TOWN AND COUNTRY PLANNING ACT 1990
TOWN AND COUNTRY PLANNING (GENERAL PERMITTED DEVELOPMENT) (ENGLAND)
ORDER 2015 – SCHEDULE 2, PART 1, CLASS A.1 (g)
AT: 37, Yew Street, Fartown, Huddersfield, HD2 2RN
Prior notification for single storey rear extension

The proposal is for erection of single storey rear extension. The extension projects 4.3m beyond the rear wall of the original dwellinghouse. The maximum height of the extension is 3.74m, the height of the eaves of the extension is 2.65m

The Authority has considered your application and it has been determined that the proposal is not acceptable and prior approval is hereby **Refused** for the following reason(s);

Drawing
UD-417

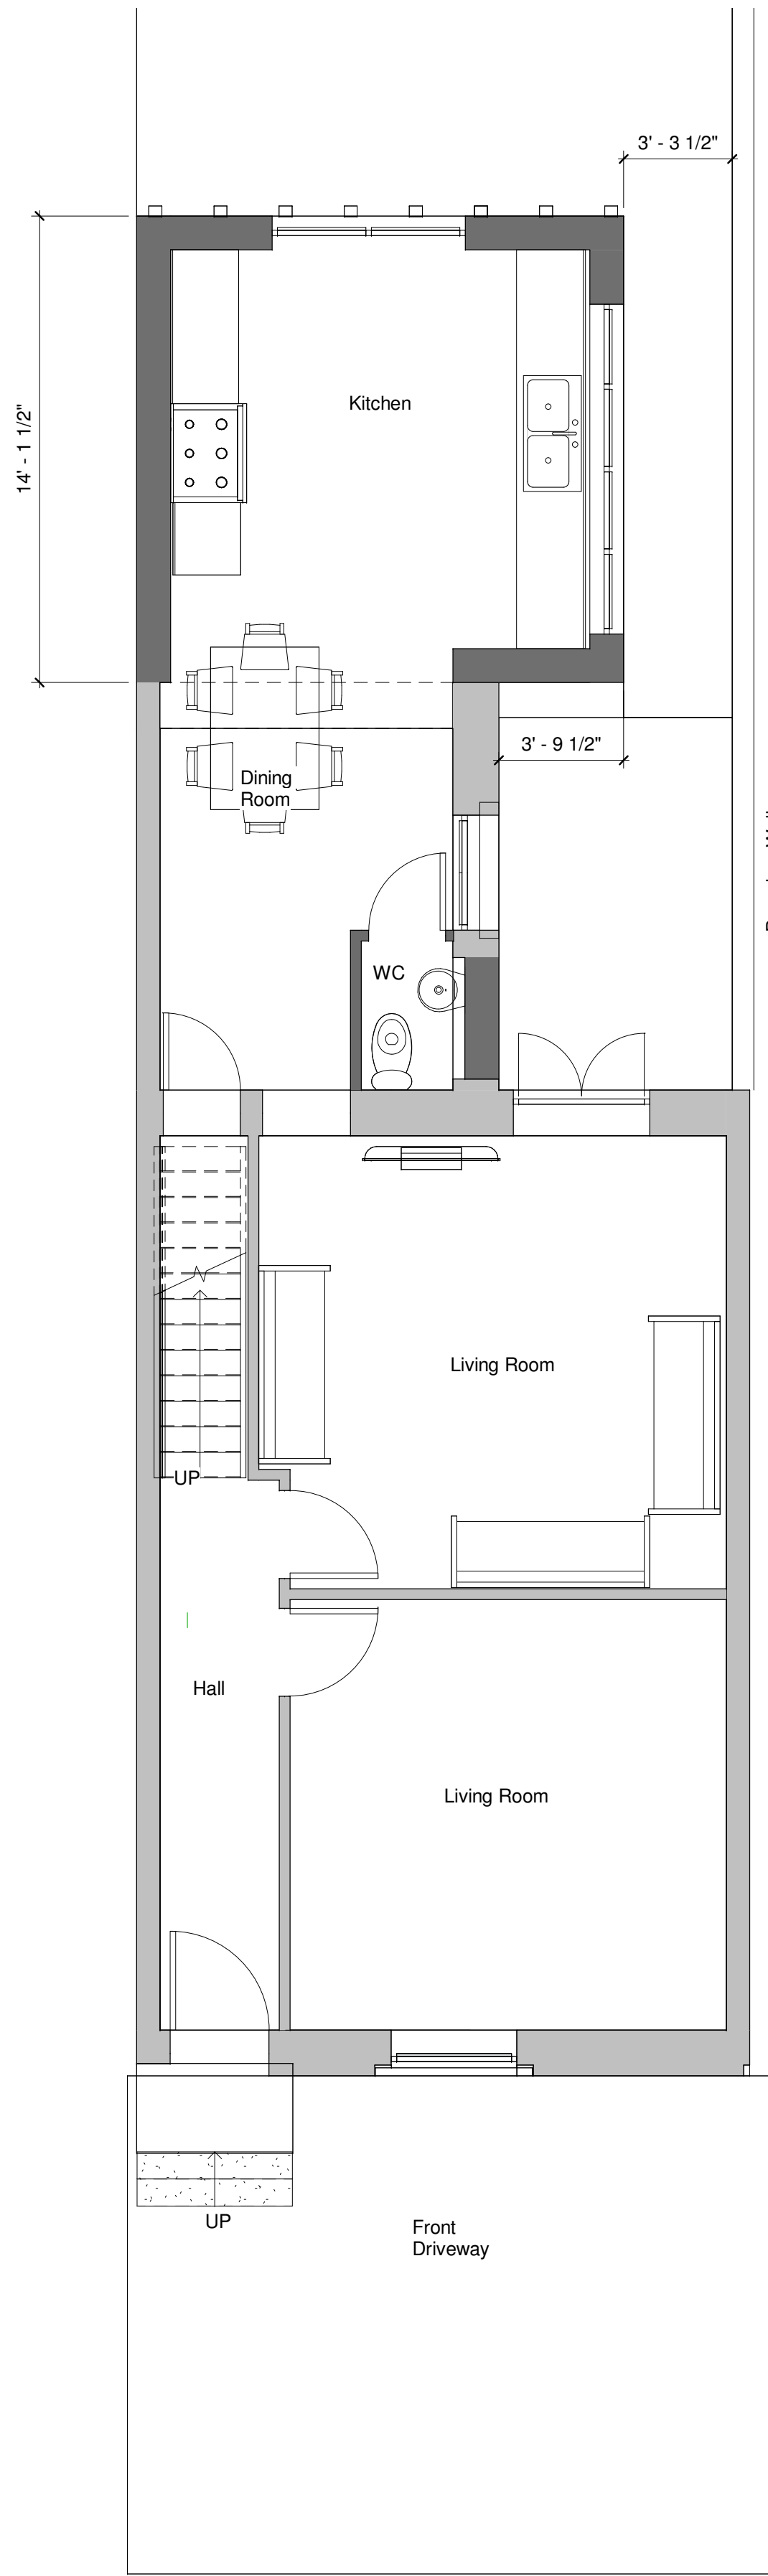
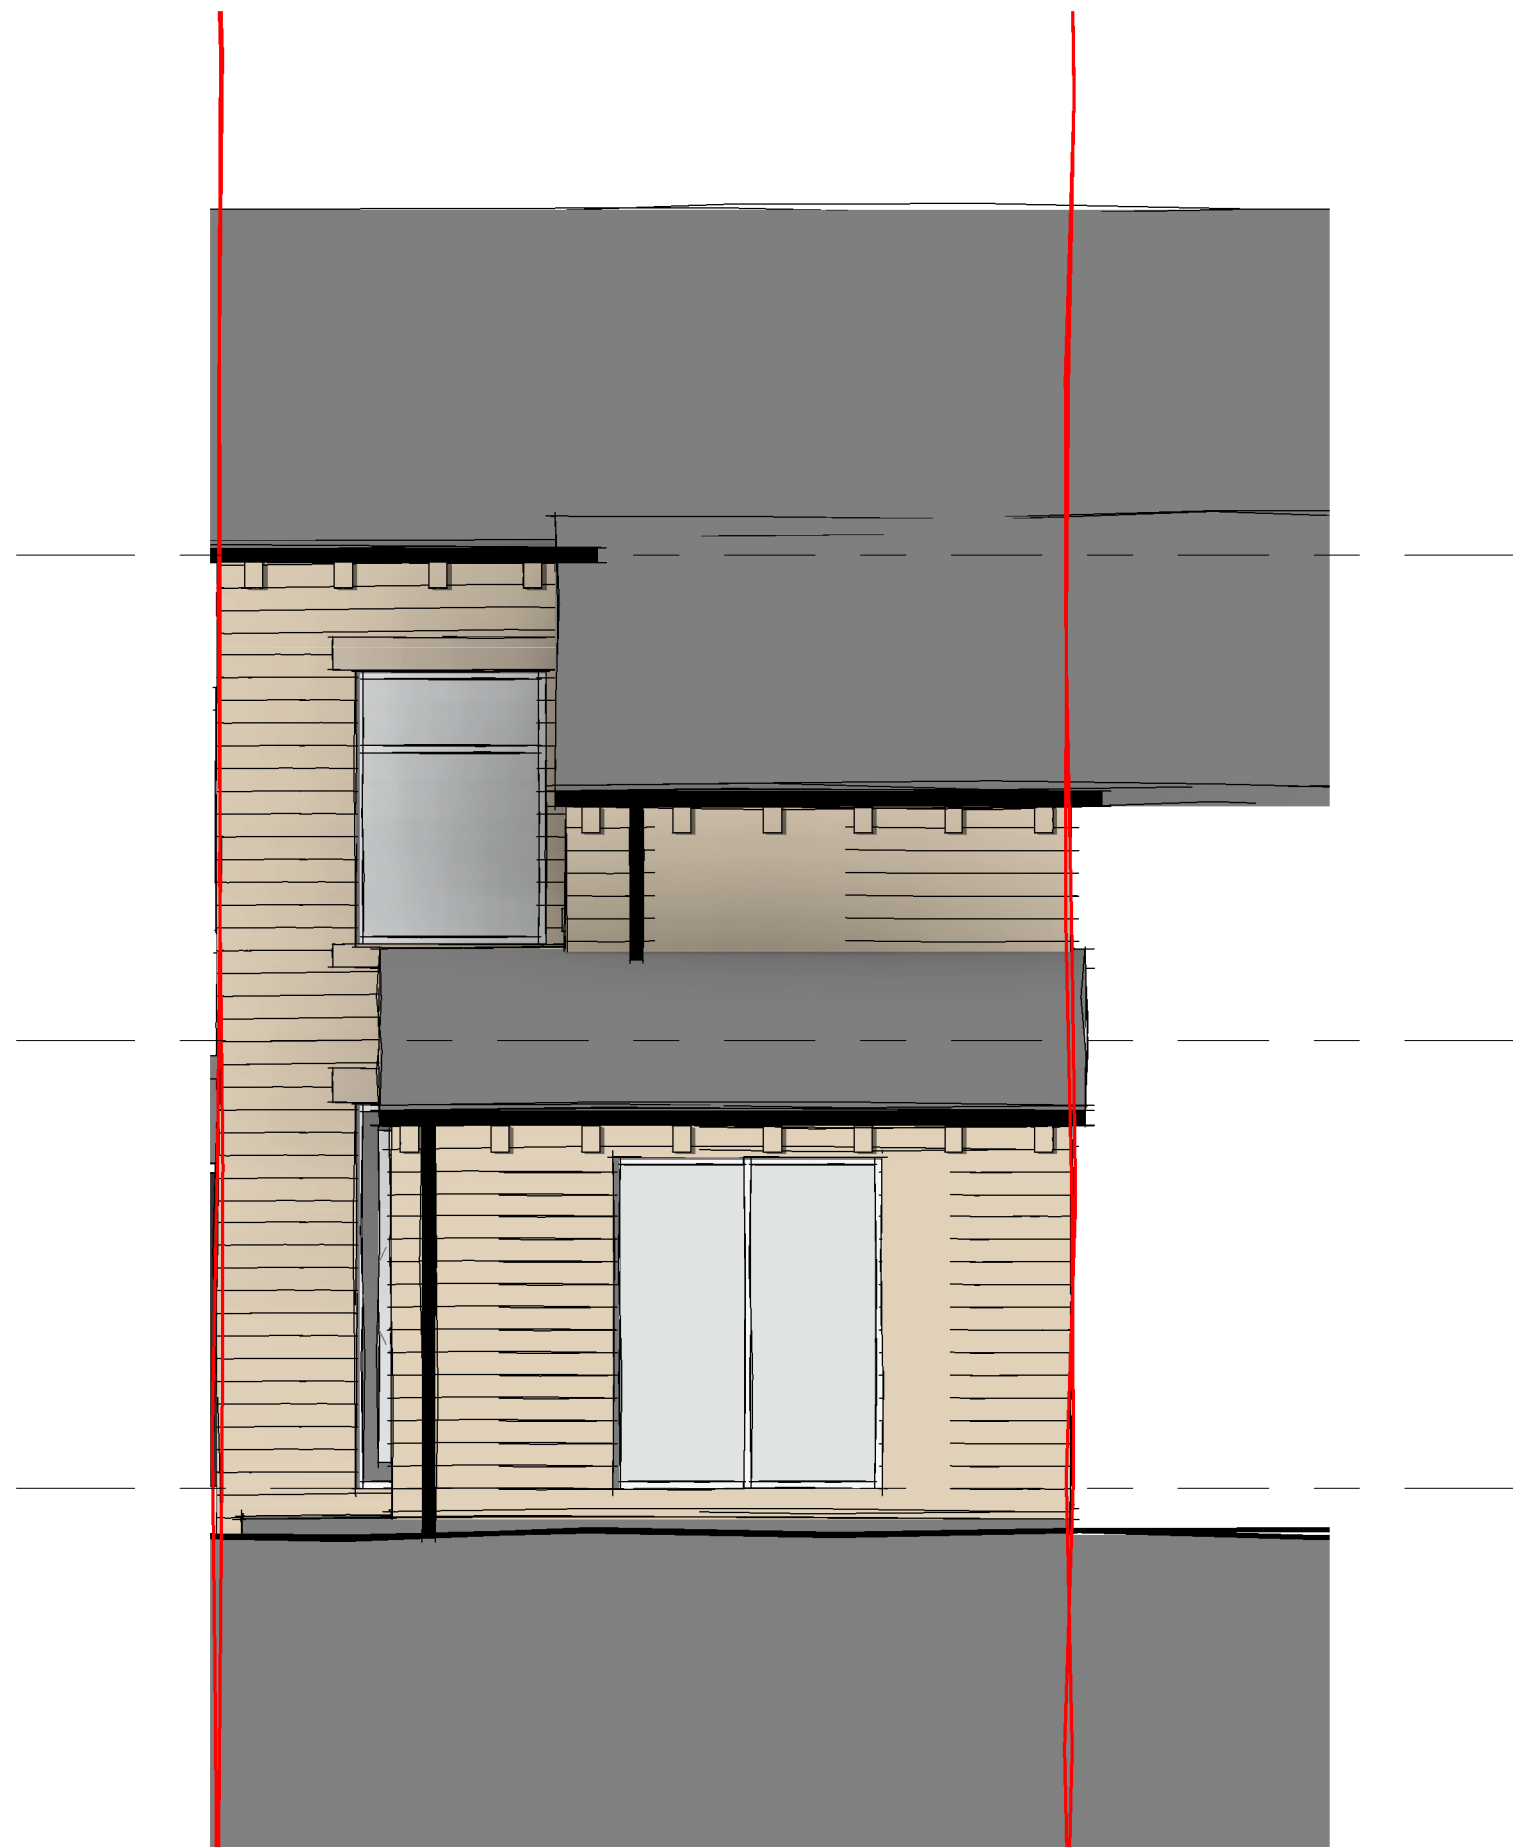
The proposed extension does not benefit from a general planning permission under Article 3(1) and Class A, Part 1 of Schedule 2 of the Town and Country Planning (General Permitted Development) (England) Order 2015 (as amended) by reason that the proposed extension projects beyond a side elevation of a wall forming part of the original dwellinghouse contrary to paragraph (j) of the Order.
